**Alternative Use Boston Projects
Boston Alternative Energy Facility Order**

Planning Inspectorate Reference: EN010095

**Deadline 5 Representations by
the Environment Agency
Unique Reference Number: 20028344**

25 January 2022

TITLE
**GENERAL LAYOUT DRAWING PLAN
FIGURE 5.1 - SHEET 1 OF 2**

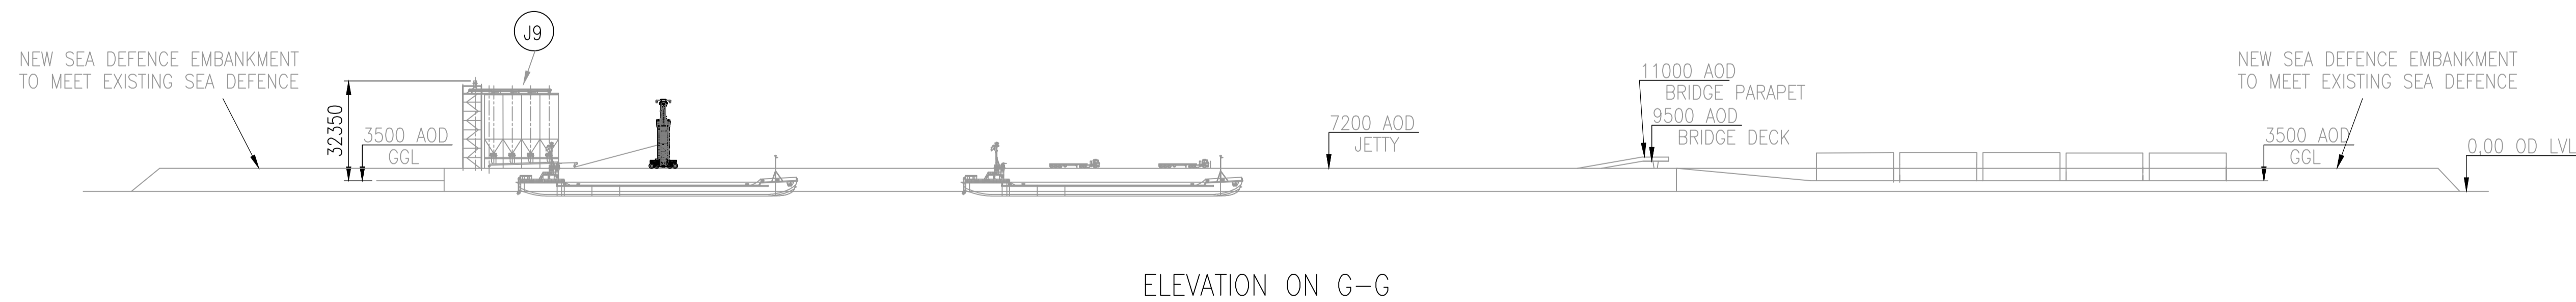
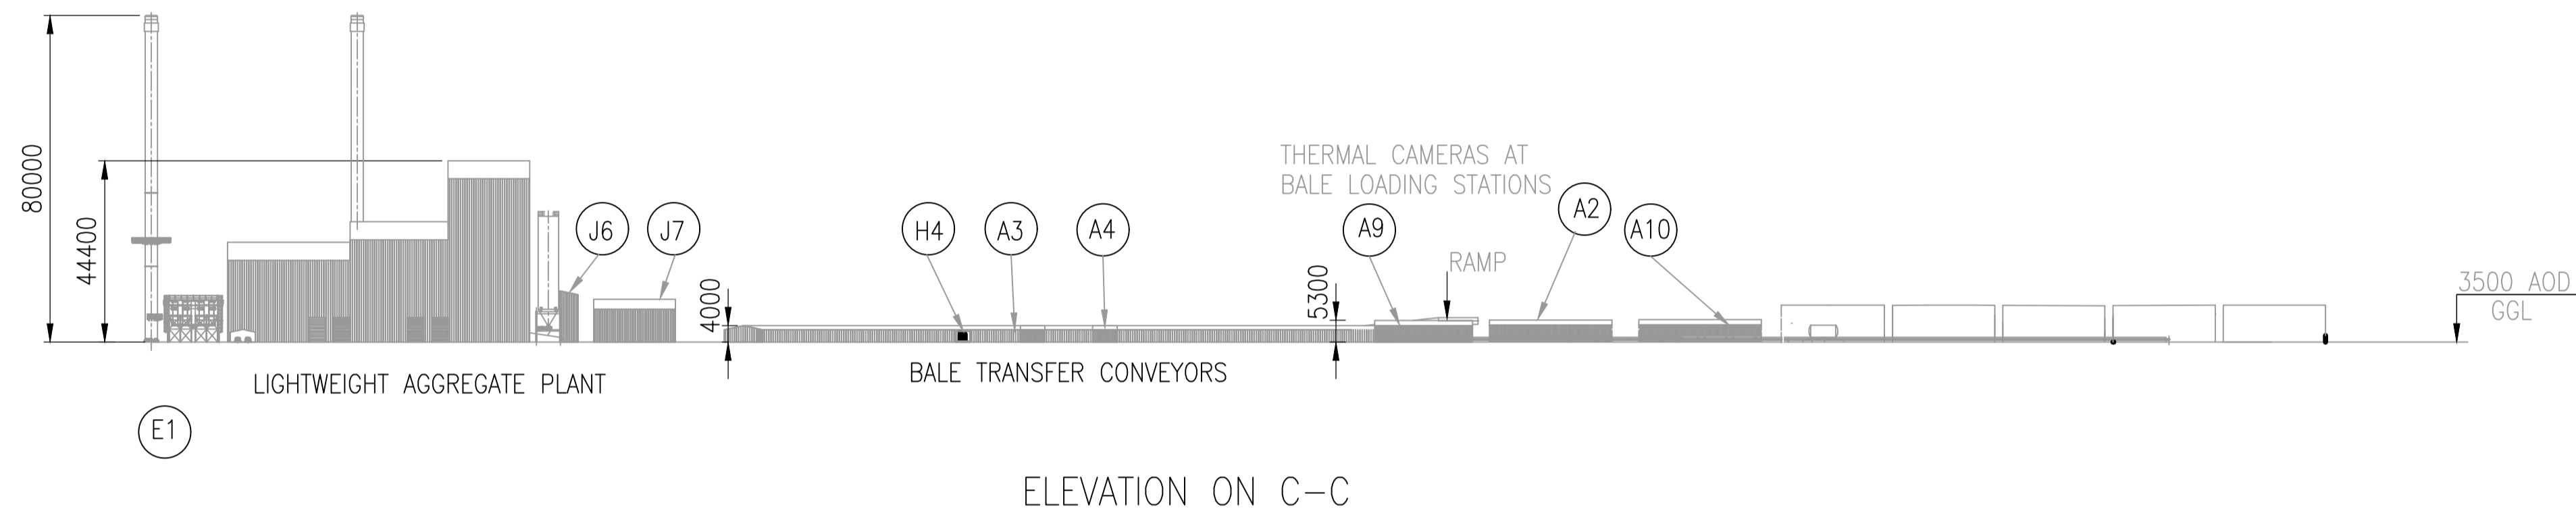
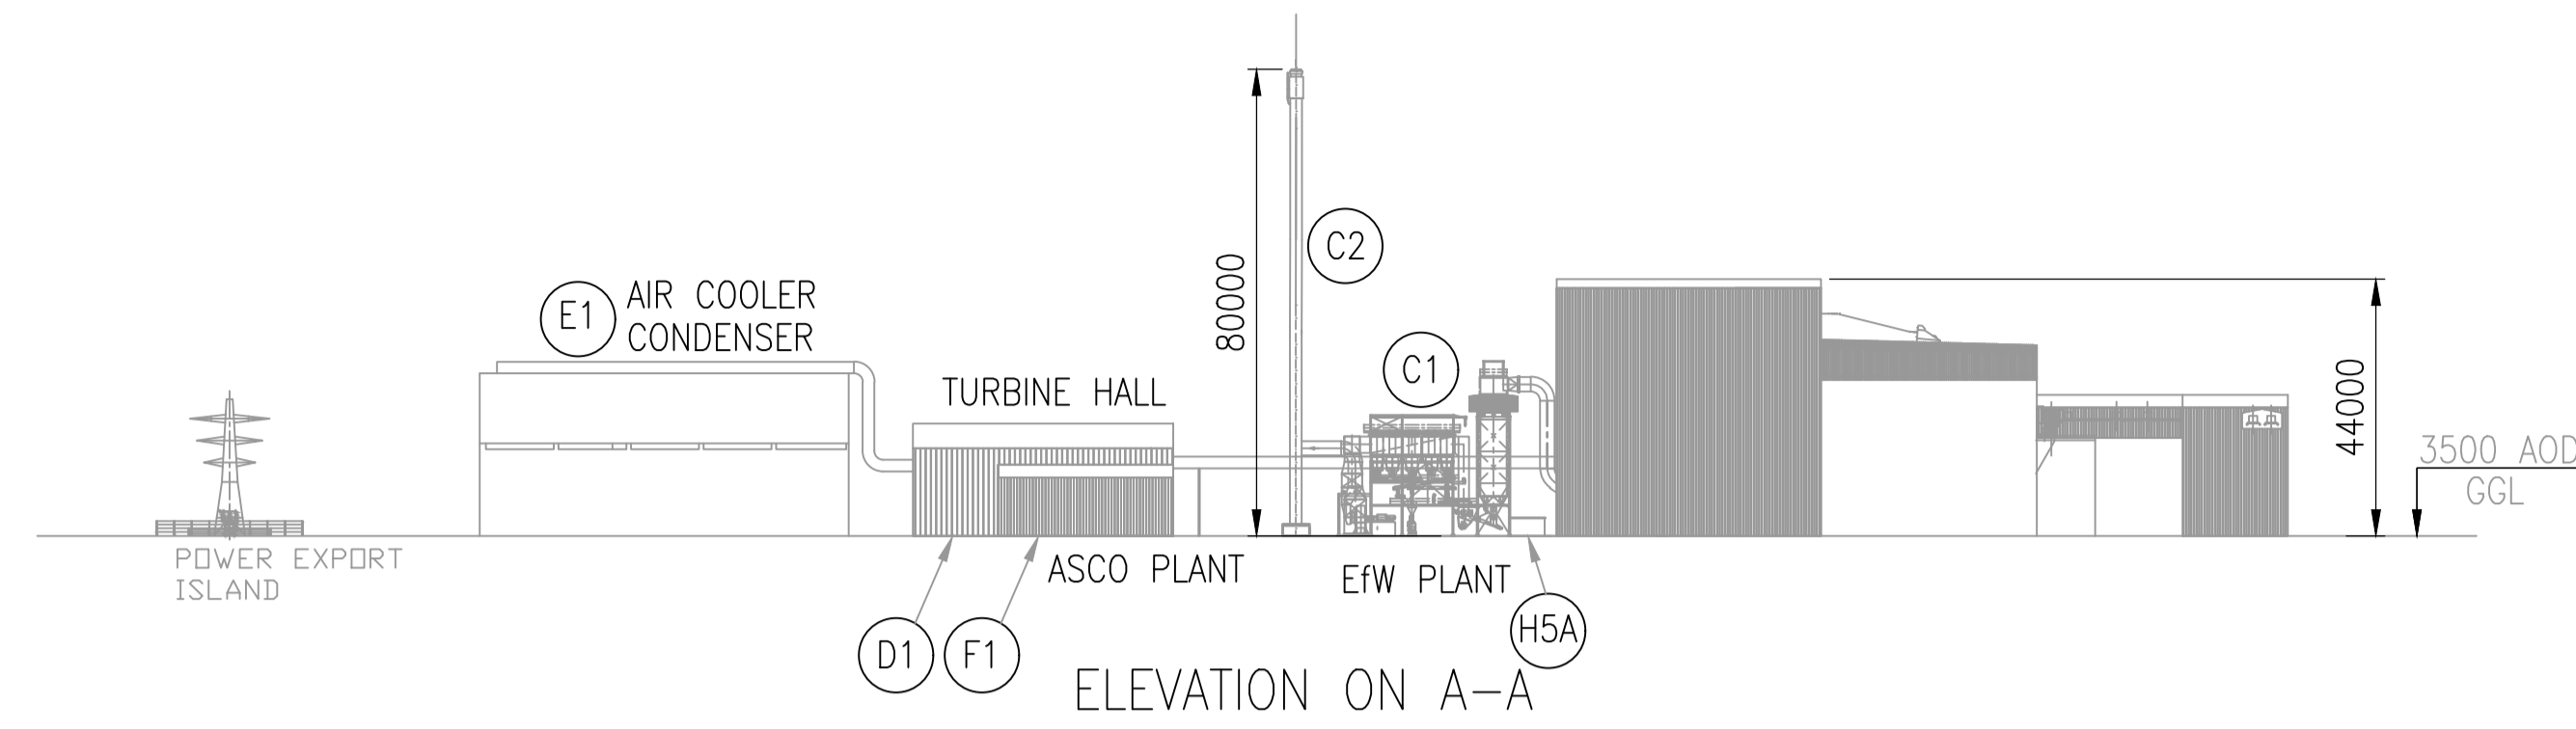
- 2.1. The Applicant has commenced pre-application discussions with the Environment Agency (EA). The EA has submitted questions on a range of topics including one on the Lightweight Aggregate (LWA) plant. This relates to the mixing of a hazardous waste stream (Air Pollution Control residues - APCr) with a non-hazardous waste stream (incinerator bottom ash - FBA) for subsequent processing within the LWA plant. The mixing of a hazardous waste with a non-hazardous waste is generally not permitted by the regulations.

- 2.2. A legal view has been obtained which states that as a starting point (as per the WI BAT C) we consider APCr and FBA should not be mixed. The Applicant would have the opportunity through the permitting process to demonstrate that it is Best Available Technique (BAT) and that there is an environmental/process benefit to the APCr being mixed with the FBA. There would need to be a clear demonstration that the mixing does not result in increased volumes of hazardous waste and that it is not being used as dilution. The APCr would need to clearly add something to the process which improves the quality of the output.

- 2.3. It would also need to be demonstrated that the LWA plant is BAT as a whole and we would consider issues including the points below under Q.3.1.23 when making this decision.

- Does the process work? Producing LWA from a combination of bottom ash and APCr has not been done before. The only thermal LWA plant currently in operation uses non-hazardous Pulverised Fuel Ash (PFA) as a feedstock.

- Evidence will need to be provided that the mixing of hazardous with non-hazardous waste is of clear benefit to the process/product and must not be used to dilute the pollutants present in the APCr.

- The environmental fate of pollutants present in the APCr must be addressed, including whether they could be released to air from the LWA process.
- Is producing LWA the best way to manage the bottom ash and APCr when compared with the conventional treatment approaches such as screening and direct use as an aggregate for bottom ash and carbonation of the APCr? How does the proposed process compare with these techniques from an environmental perspective?

- Producing LWA is an energy intensive process and releases CO₂. No waste derived fuels are proposed, instead fuel oil would be used.
